Application for a Non-Material Amendment Following a Grant of Planning Permission

Erection of a lower ground floor rear glazed extension, vaults integration and front lobby extension.

21/03923/FULL

Omission of the rear basement glazing extension.
Introduction of an external Air Conditioning Unit under the basement rear window.

Project	Flat 1 Extension @ 97 St George's Drive		
title	Lower Ground Floor Plan - Proposed		
drwg	0042-GA-01-P-008	date	10/12/23
client	Mikkel Skajem Flat 1 - 97 St George's Drive London SW1V 4DB	rev	P 3.0
		scale	1:50 @ A3

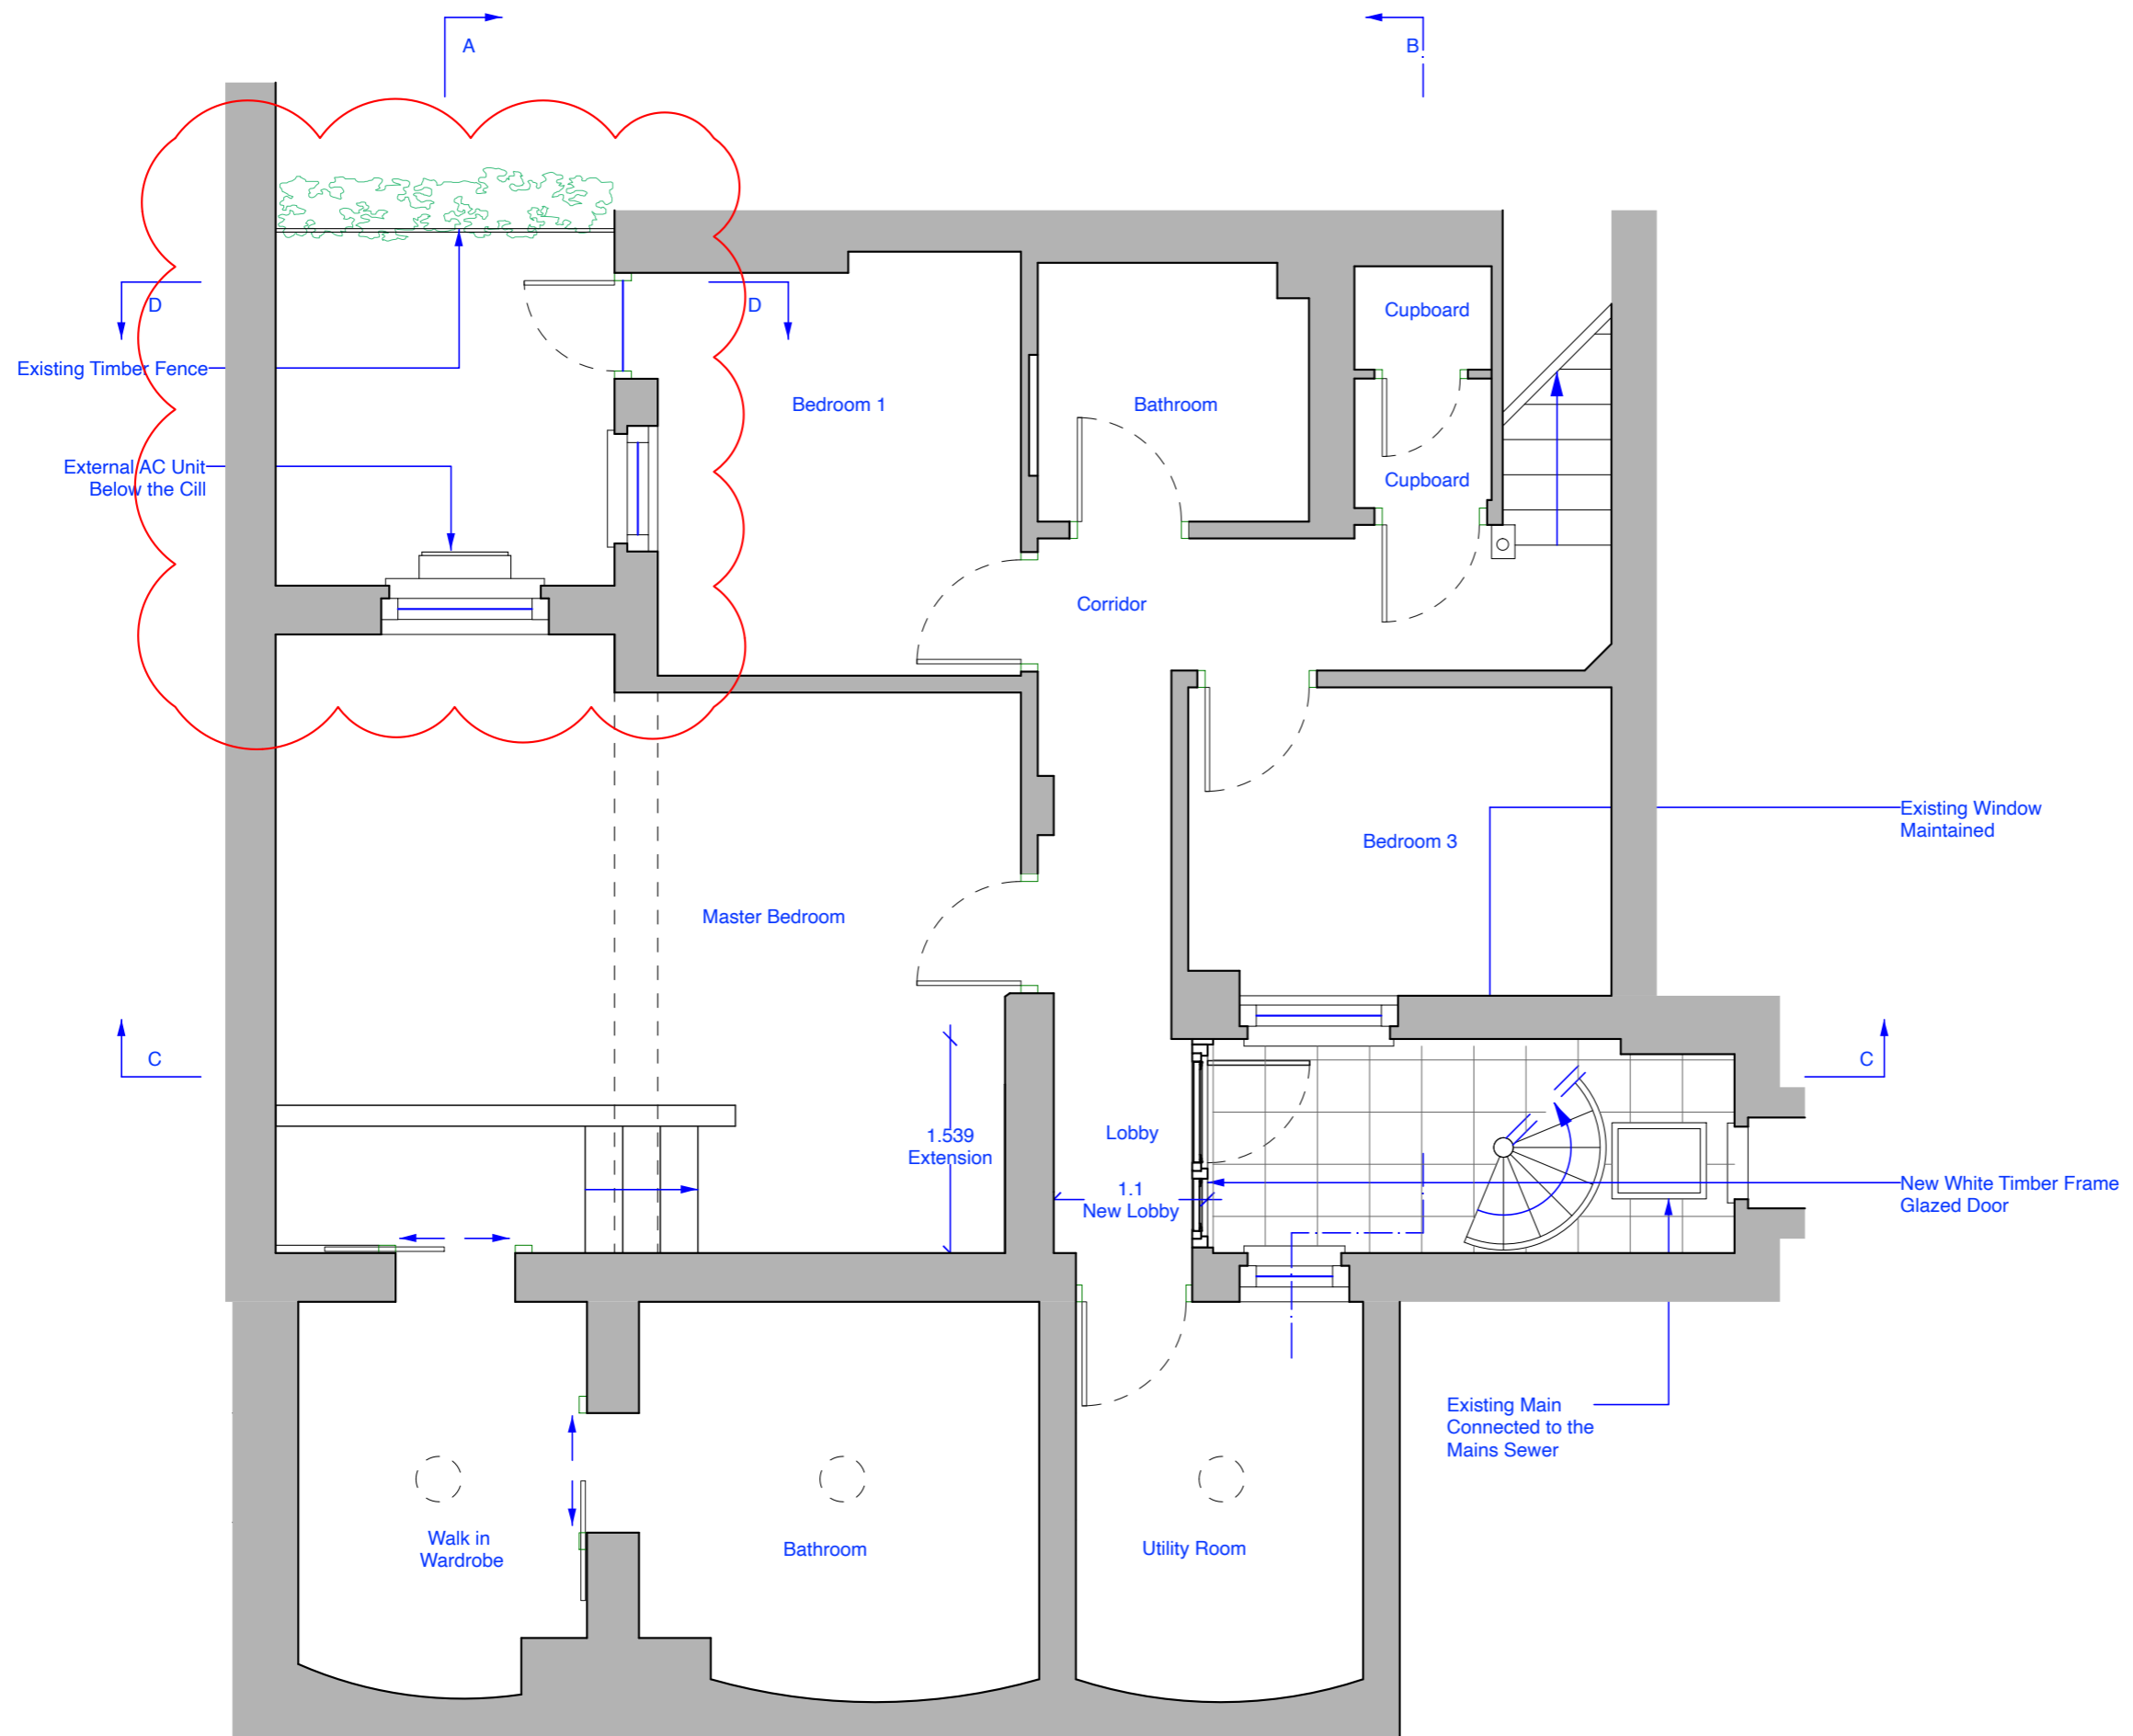
The client, Mr Mikkel Skajem, is not considering the erection of the rear glazed extension and would like to install one air conditioning unit under the basement window.

0042-GA-01-P-008-P03 Lower Ground Floor Plan Proposed
0042-GA-01-P-009-P03 Section A-A Winter-garden Proposed
